Subject: SV-25-00001 Allen - Notice of Application

RE: 202500772, SV-25-00001

TO: All Staff
FROM: Public Works Plan Review Team
DATE: March 26, 2025
SUBJECT: SV-25-00001 Allen

SUBJECT: WDFW COMMENTS ON SV-25-00001 Allen Shoreline Variance

320 MORNING DOVE LANE
A PORTION OF THE SE 1/4 OF THE SE 1/4 OF SECTION 22, T. 20 N., R. 14 E., W.M.
KITITITAS COUNTY, STATE OF WASHINGTON

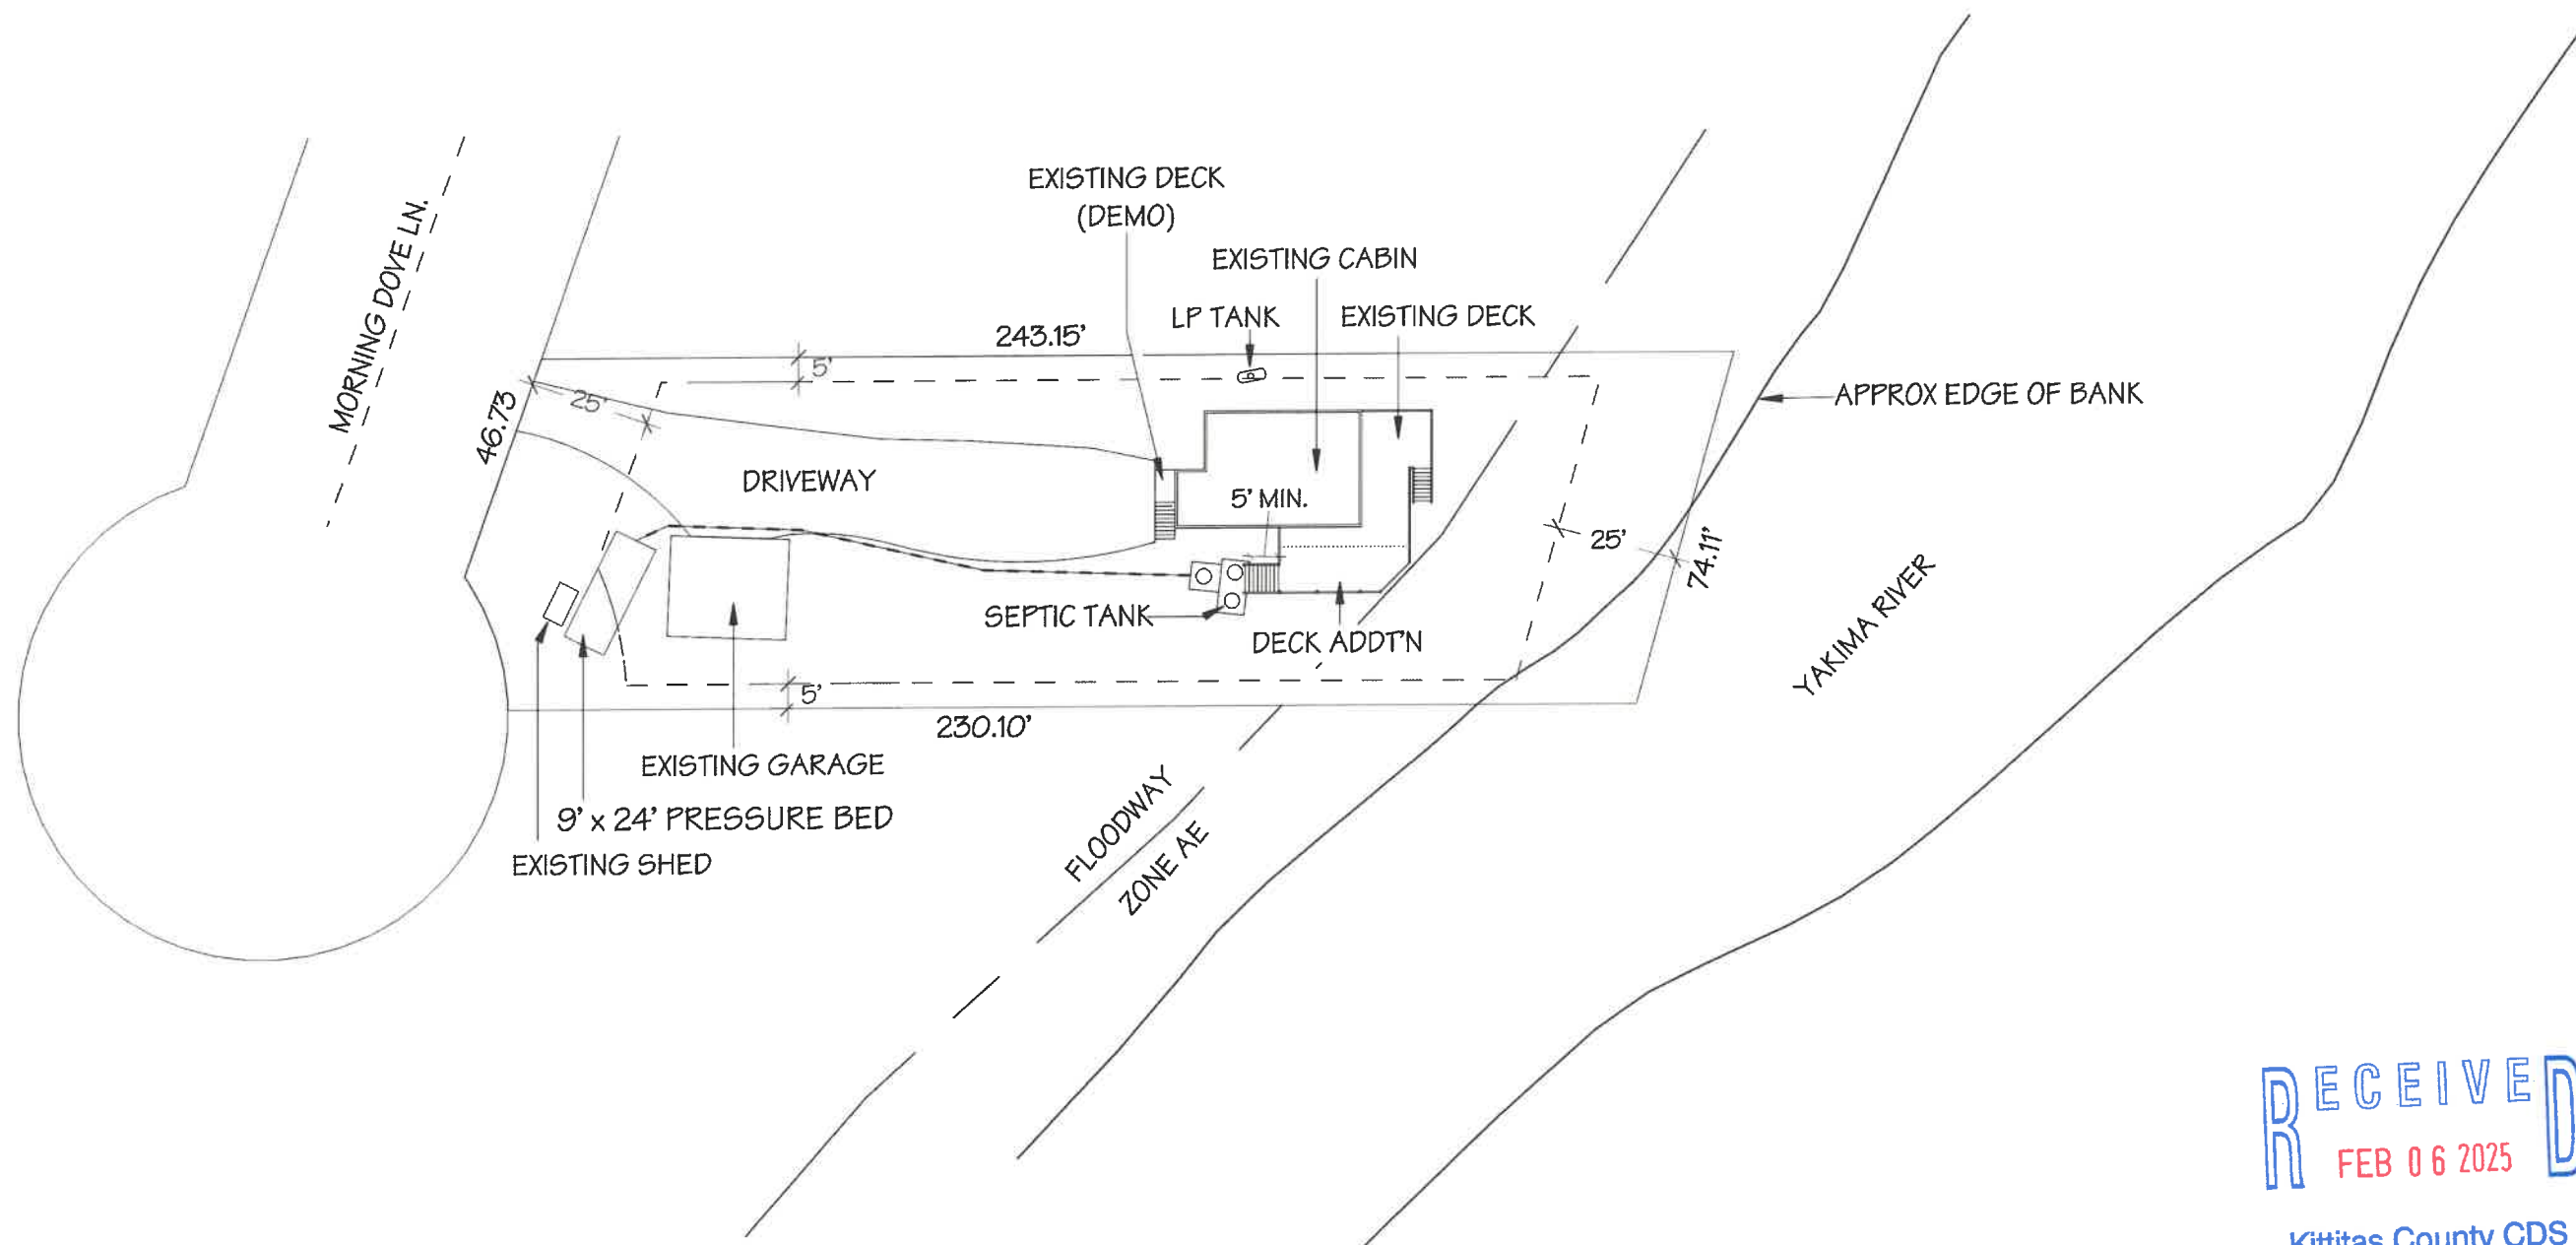
ENGINEERING	Except as exempted in KCC 14.05.060, no grading or filling upon a site involving more than one hundred (100) cubic yards shall be performed without a grading permit from the County Engineer or Public Works designee (KCC 14.05.050). An application for grading in excess of five hundred (500) cubic yards shall be accompanied by an engineered grading plan (KCC 14.05.080). (CP)
FLOOD	<p>A floodplain development application is required for the proposed project. Since this is a remodel/addition to an existing structure a substantial improvement worksheet must also be submitted with the application. If the project is a substantial improvement to the post-FIRM structure, the whole structure must meet current KCC 14.08 Flood Damage Prevention standards.</p> <p>A portion of the parcel is within the floodway. The deck must be outside of the floodway boundary, or a no-rise certificate must be provided that shows the encroachment would not cause any increase to the 100-year flood elevation. Prior to construction it is advised to have a surveyor mark the floodway boundary on site to avoid unintentional encroachment. The floodway boundary being marked on site will be required for the final flood inspection. (SC)</p>

The proposed project will expand the deck by 179 square feet into the Shoreline buffer along the Yakima River and proposes planting 20 livestakes along the bank as mitigation. The proposed mitigation is insufficient as proposed and WDFW recommends a more robust planting plan for the shoreline that includes monitoring, maintenance, reporting, and permanent protections to ensure the additional encroachment into the buffer does not negatively impact aquatic resources. WDFW recommends 1) that the mitigation planting area be at least as big as the area of encroachment (179 square feet), 2) that the newly vegetated area have at least 80% survival after three years, and 3) that there are permanent protections on the mitigation area associated with the proposed permanent encroachment into the buffer.
